**Planning Department  
Transportation Development Services**

May 21, 2015

**Re: State of New Mexico Environment Department-Springer Building  
121 Tijeras Ave. NE  
Traffic Circulation Layout  
Engineer's/Architect's Stamp dated 4-20-15 (K14-D036)**

SITE PLAN - TEMPORARY PARKING IMPROVEMENTS - SCALE = 1/32" = 1' - 0"

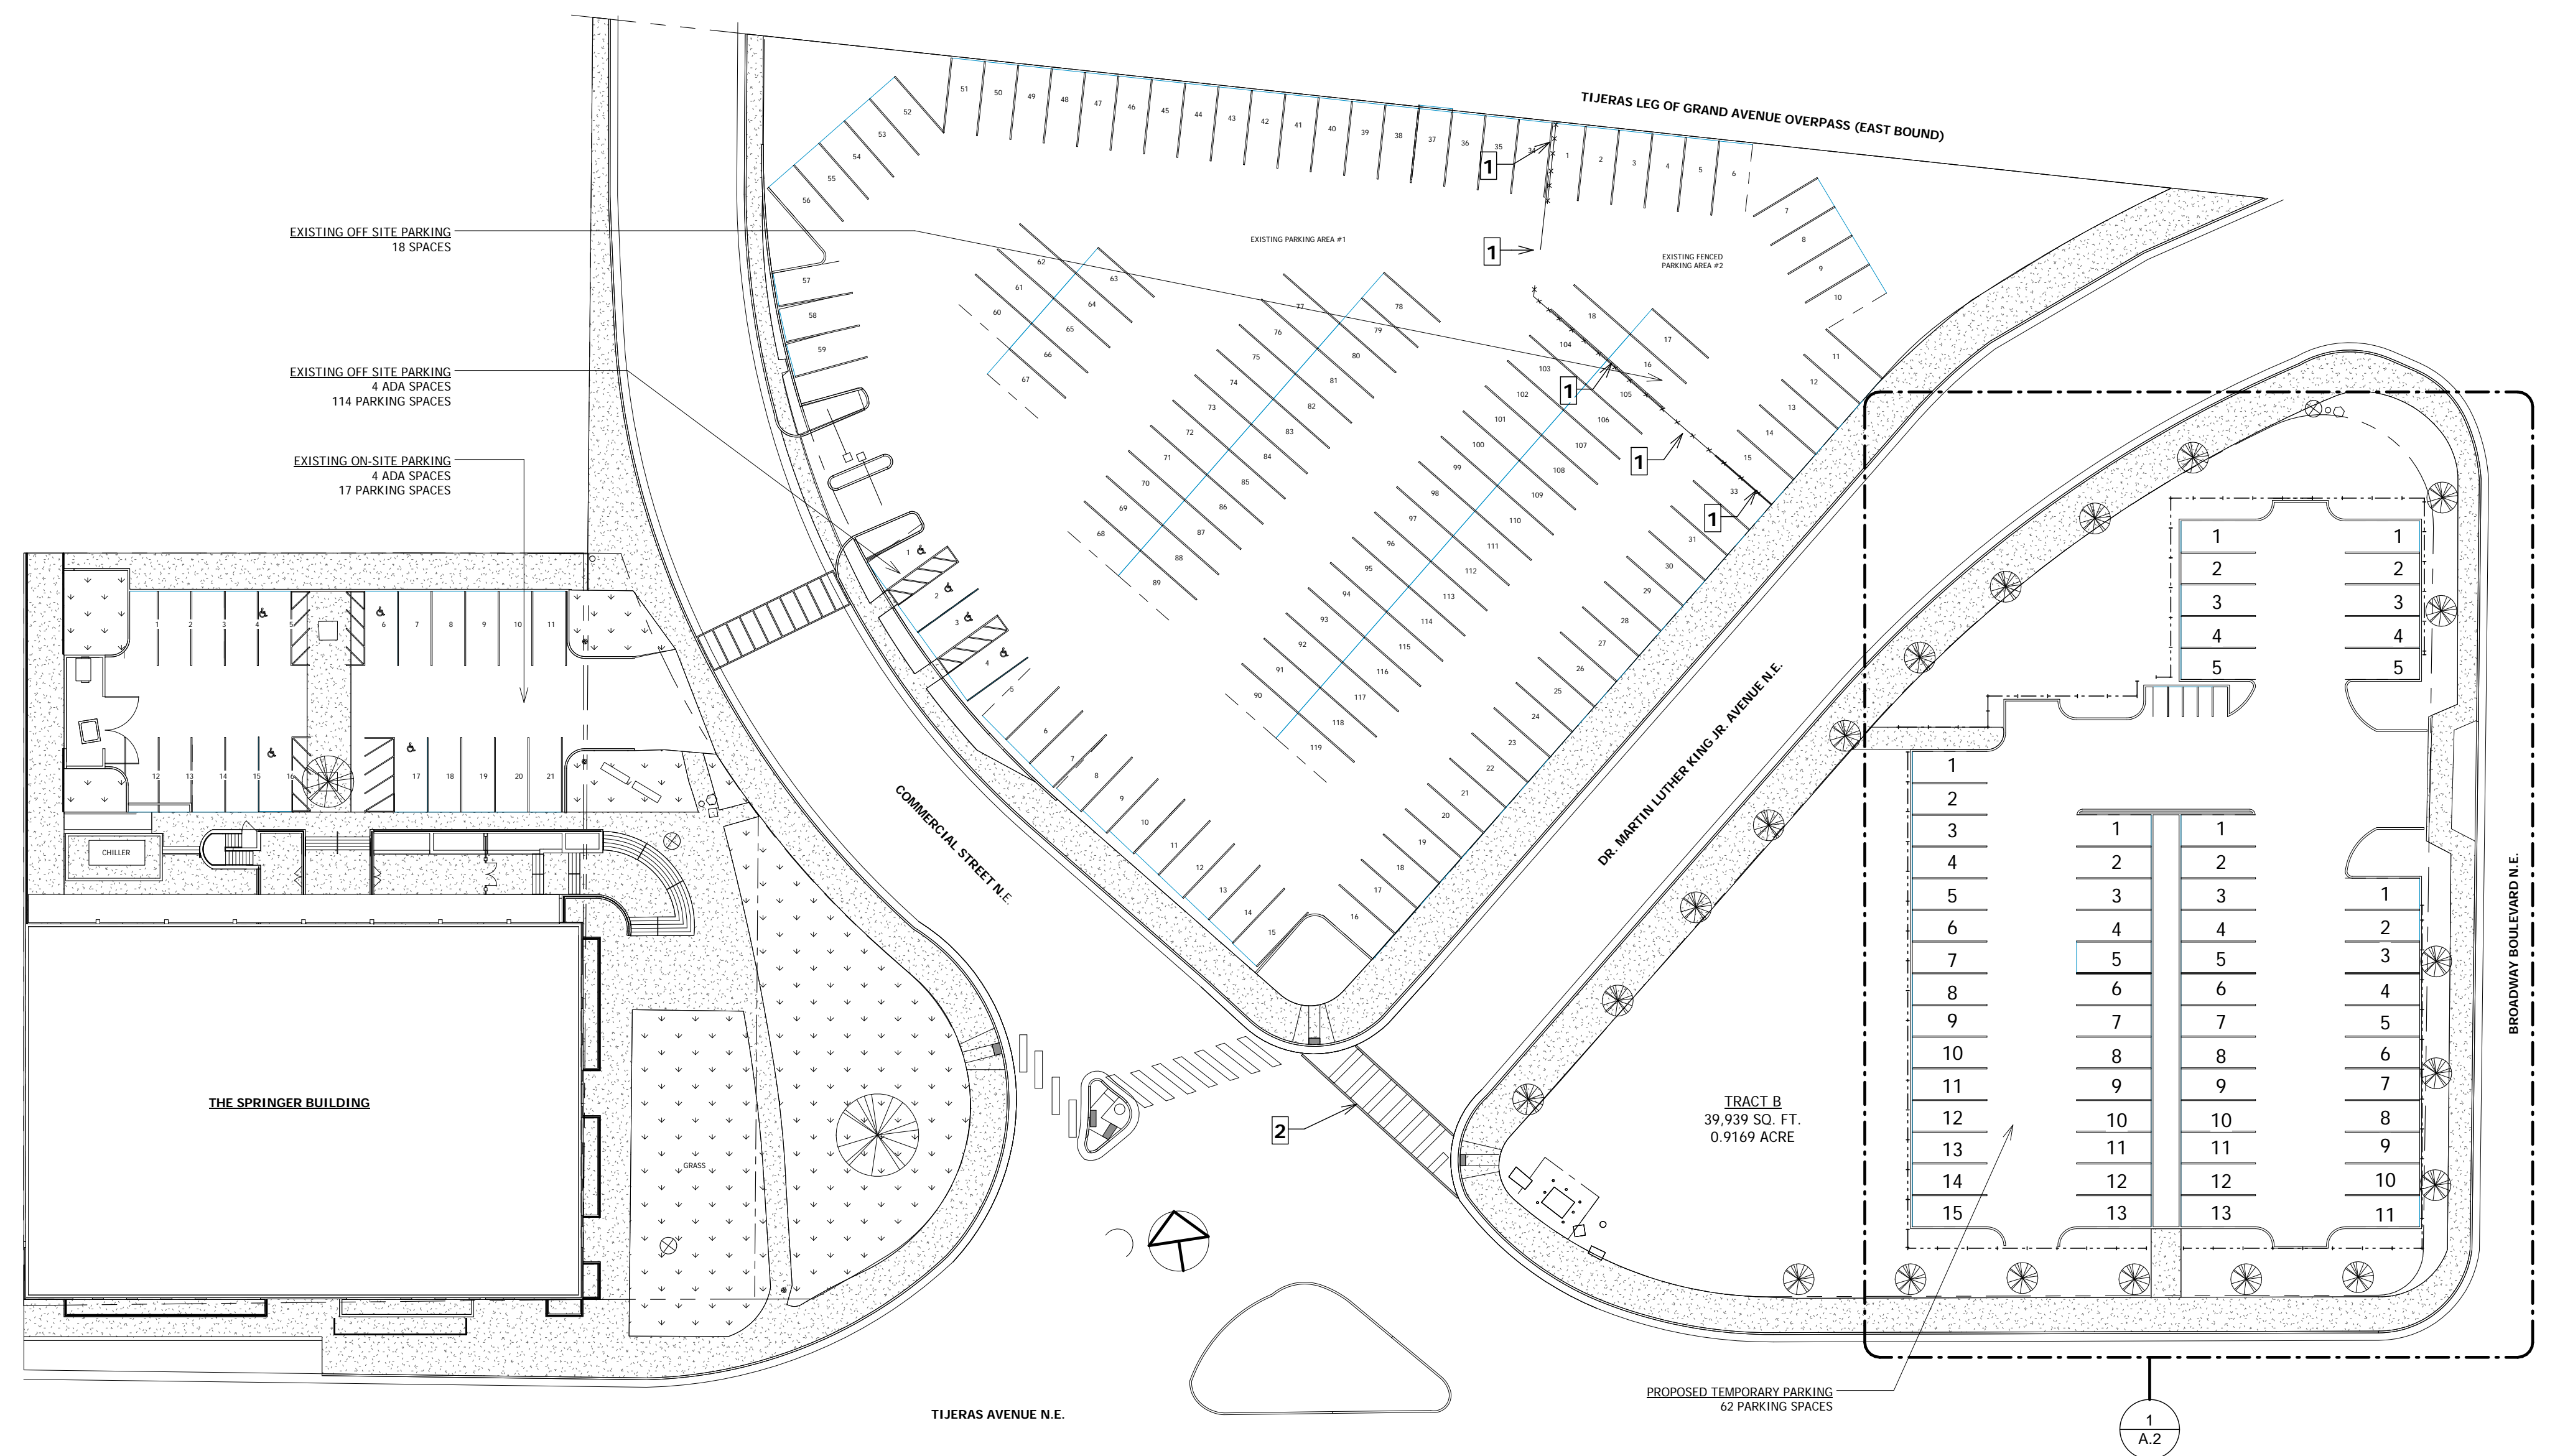
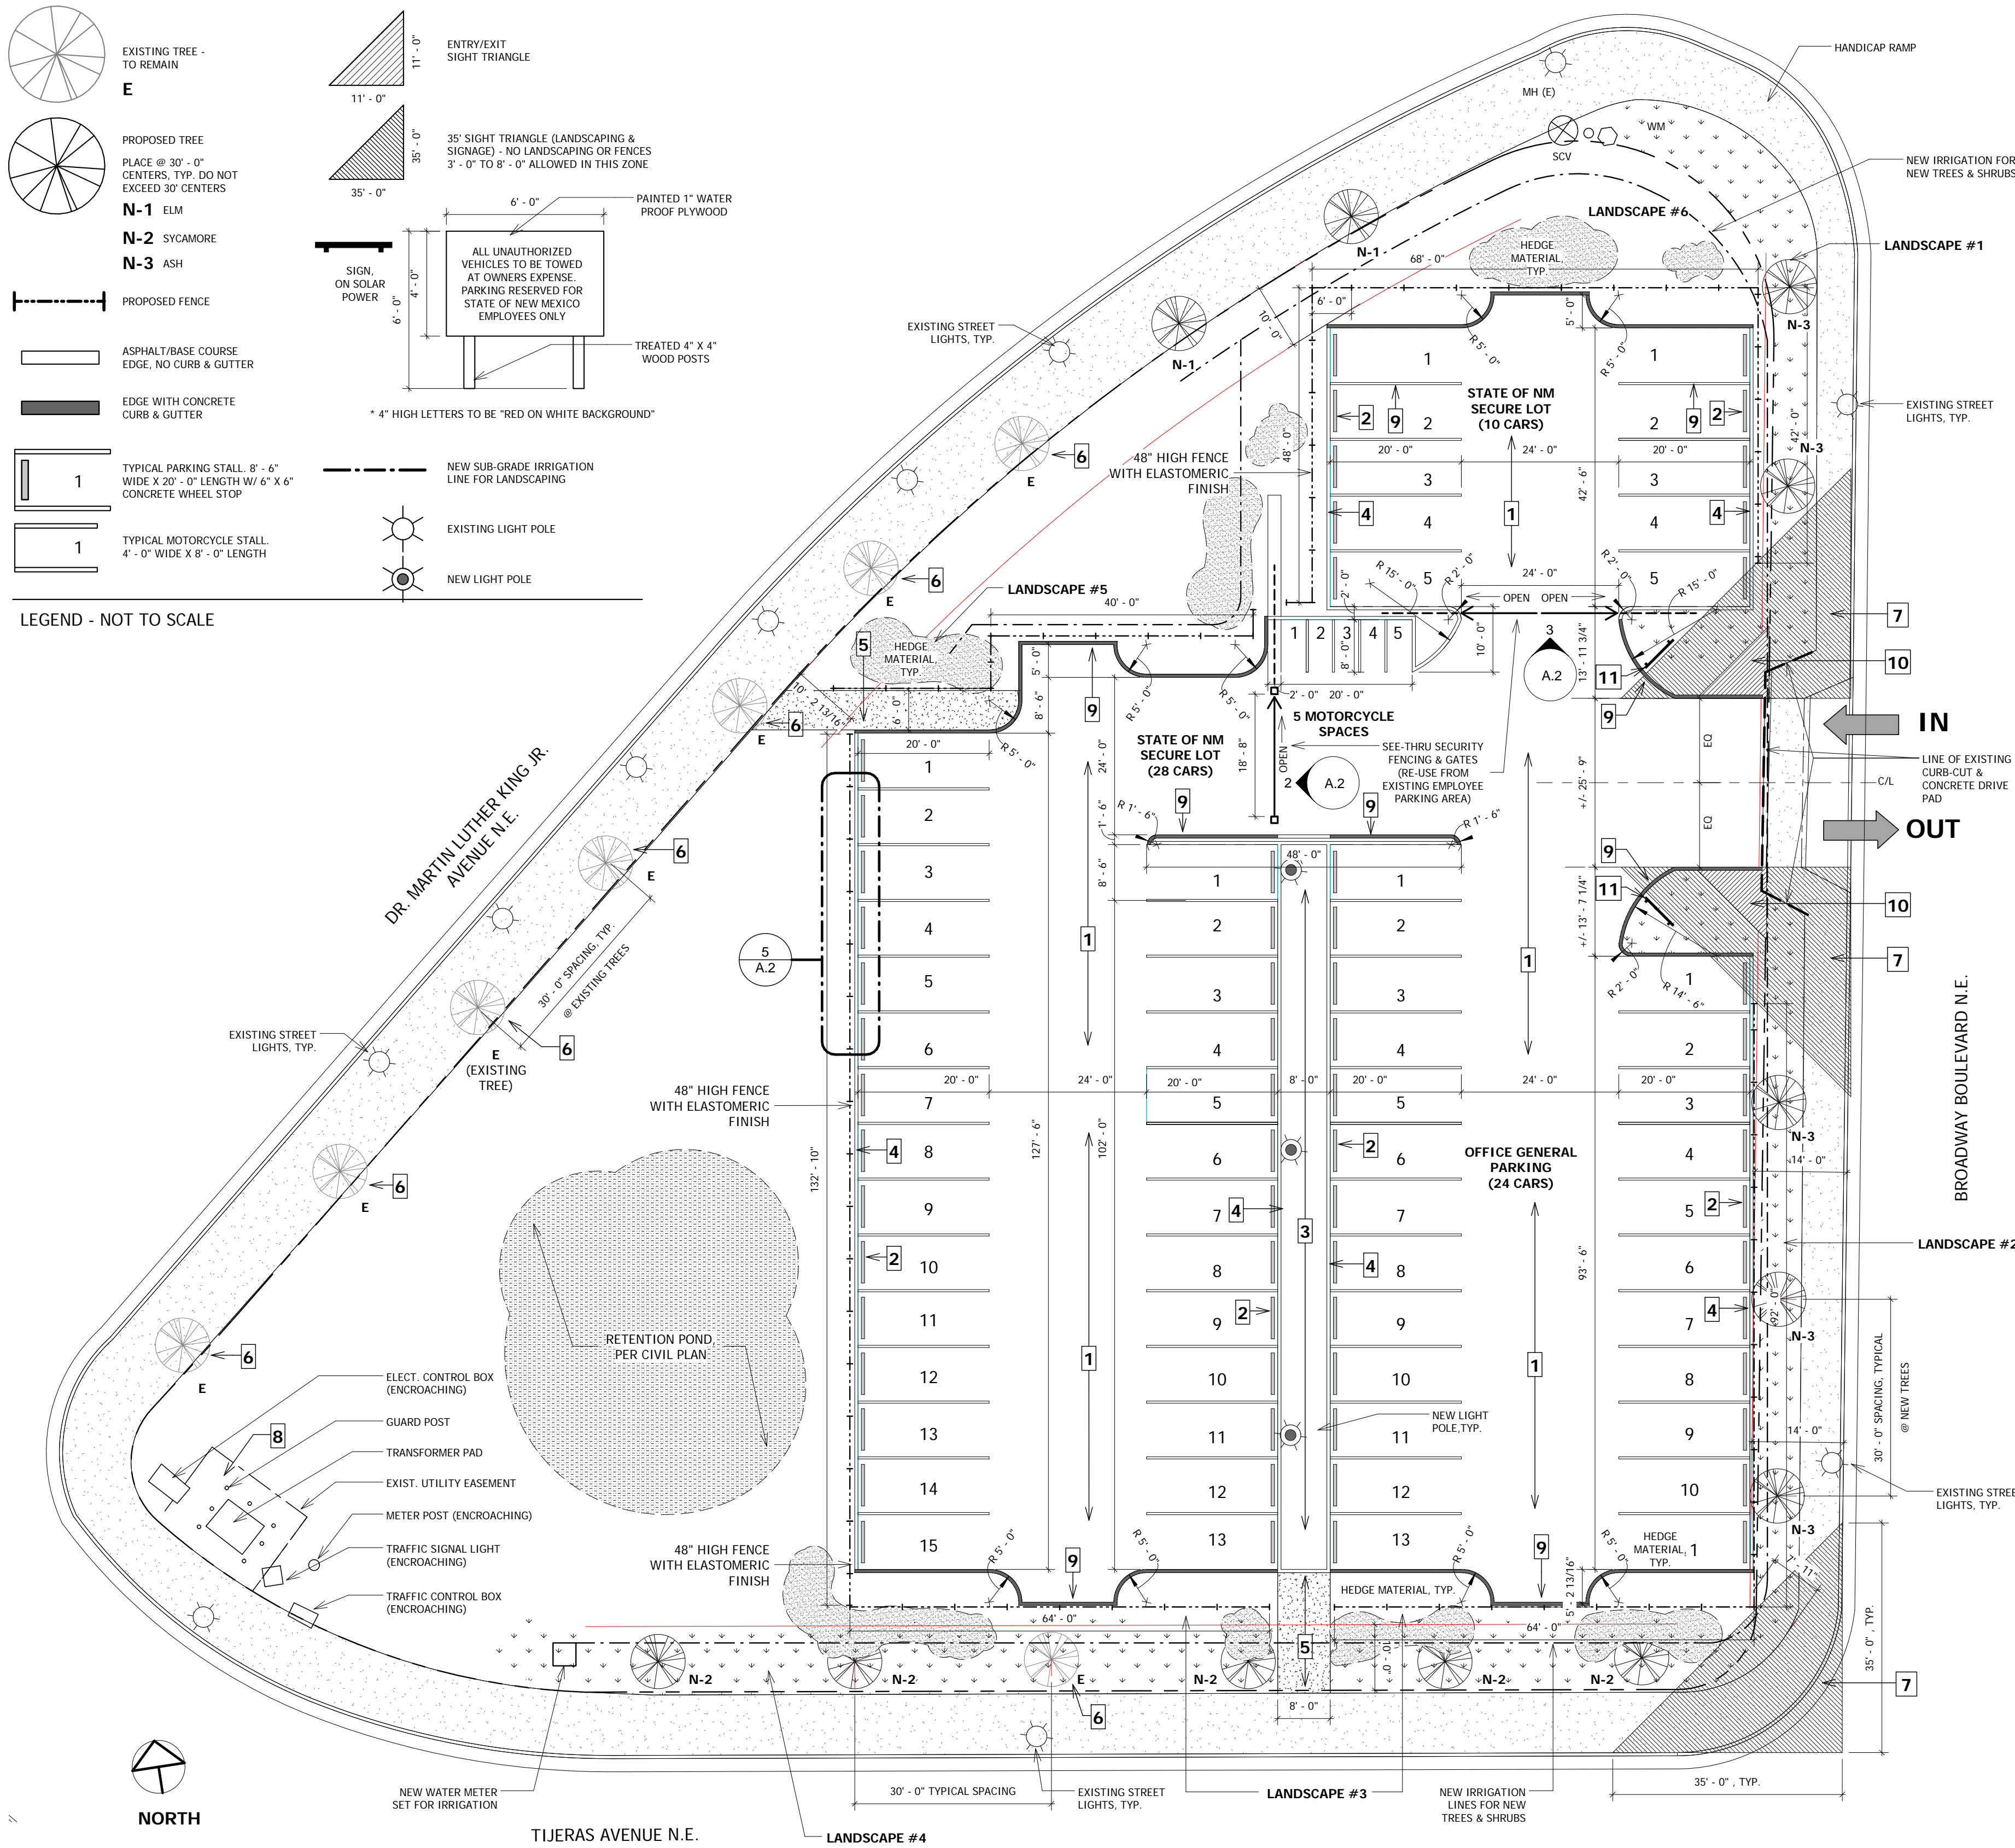
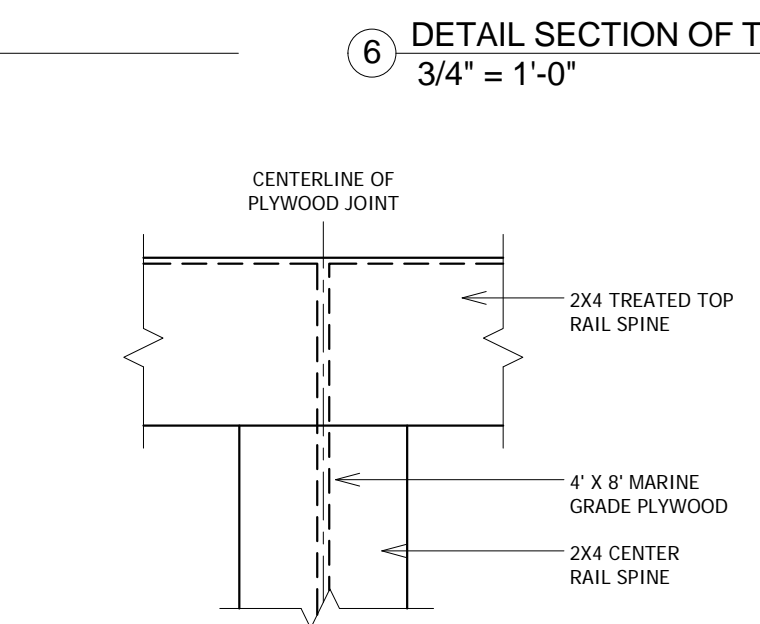
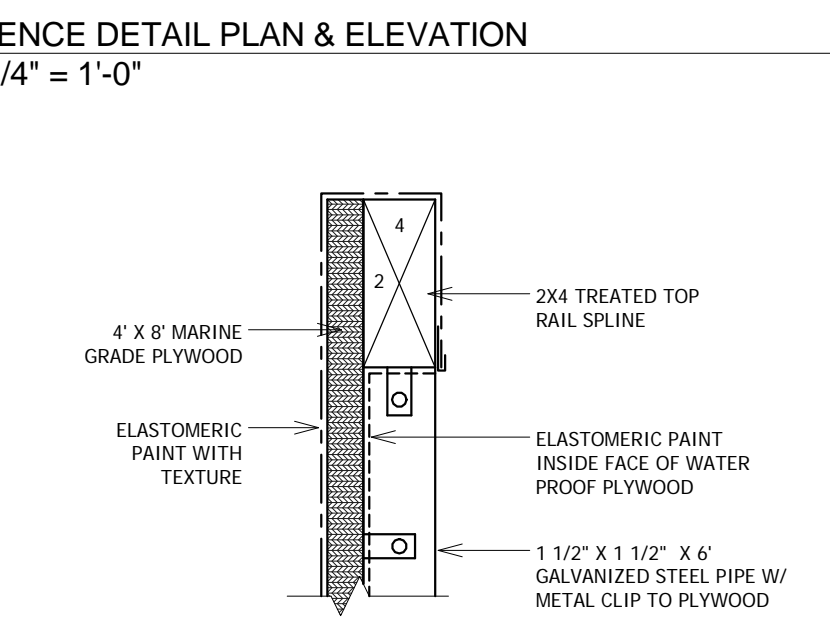
1. Please show a vicinity map showing the location of the development in relation to streets and well known landmarks.
2. Label new lot as "Overflow Parking".

3. Clarify the extents of the current phase. Please label existing buildings.
4. Please clarify the use of temporary parking. Is it be used just during construction?

5. Please identify all existing buildings, doors, structures, sidewalks, curbs, drive pads, walls and anything that influences the parking and circulation on the site.

6. Identify all existing access easements and rights of way with dimensions.
7. Identify the right of way width, medians, curb cuts, and street widths on Tijeras Ave., Dr. Martin Luther King Jr.Ave., and Commercial St.

8. The lot must be graded and surfaced with blacktop or equal: Two inches of asphalt concrete on a prime coat over a four inch compacted subgrade, or a surface of equal or superior performance characteristics. If street curbs and gutters exist adjacent to the parking lot property on a side where lot egress is allowed, the surfacing shall be blacktop for the width of the egress drive(s) and shall extend inward from the property line a minimum of 25 feet along all normal lines of egress traffic flow from the lot. All paving shall be maintained level and serviceable (i.e. no potholes). The City Engineer will have to approve a grading and drainage plan before the asphalt can be installed.

9. For parking lots of 20 or fewer spaces: A layer at least two inches thick of gravel sized from 3/8 minimum to one inch maximum diameter, at least ½ inch of which shall be maintained on the surface; gravel shall be kept off the right-of-way.

11. The lot shall have barriers which prevent vehicles from extending over the sidewalk or abutting lots, or beyond the sides of a parking structure. The plans do already address providing concrete vehicular wheel stops.

12. Please list the width and length for all existing and proposed parking spaces. Please clearly detail how each parking space is to be marked and if there will be curb stop or car parking bumpers installed in each parking space. The minimum parking space width is 8.5 ft.

13. The ADA van accessible sign must have the required language per 66-7-352.4C NMSA 1978 **"Violators Are Subject to a Fine and/or Towing."** Please show a detail of the existing ADA signs.

14. The ADA access aisle shall have the words **"NO PARKING"** in capital letters, each of which shall be at least one foot high and at least two inches wide, placed at the rear of the parking space so as to be close to where an adjacent vehicle's rear tire would be placed. (66-1-4.1.B NMSA 1978)

15. Show all drive aisle widths and radii.
16. List radii for all curves shown; for passenger vehicles, the minimum end island radius is 15 feet. Landscape island radius for delivery trucks, fire trucks, etc. is 25 feet or larger

17. Per the DPM, a 6 ft. wide ADA accessible pedestrian pathway is required from the public sidewalk to the building entrances. Please clearly show this pathway and provide details from the proposed temporary parking.

18. Per the DPM, a 6 ft. wide ADA accessible pedestrian pathway is required from the HC parking stall access aisles to the building entrances. Please clearly show the ADA pedestrian pathway from the existing and proposed parking to the building entrance.

19. Provide a min 6" or max 8" high concrete barrier curb or other acceptable barrier between landscaping and parking areas and/or drive aisles.
20. Please provide a sight distance exhibit for entrance off of Broadway Blvd. (see the *Development Process Manual, Chapter 23, Section 3, Part D.5 Intersection Sight Distance*).

21. Please add the following note to the clear sight triangle: "Landscaping and signage will not interfere with clear sight requirements. Therefore, signs, walls, trees, and shrubbery between 3 and 8 feet tall (as measured from the gutter pan) will not be acceptable in this area."
22. Please specify the City Standard Drawing Number when applicable.
23. Work within the public right of way requires a work order with DRC approved plans.
24. See Chapter 23, Section 6 of the City of Albuquerque *Development Process Manual*, for appropriate drive pad widths.
25. Please include two copies of the traffic circulation layout at the next submittal.
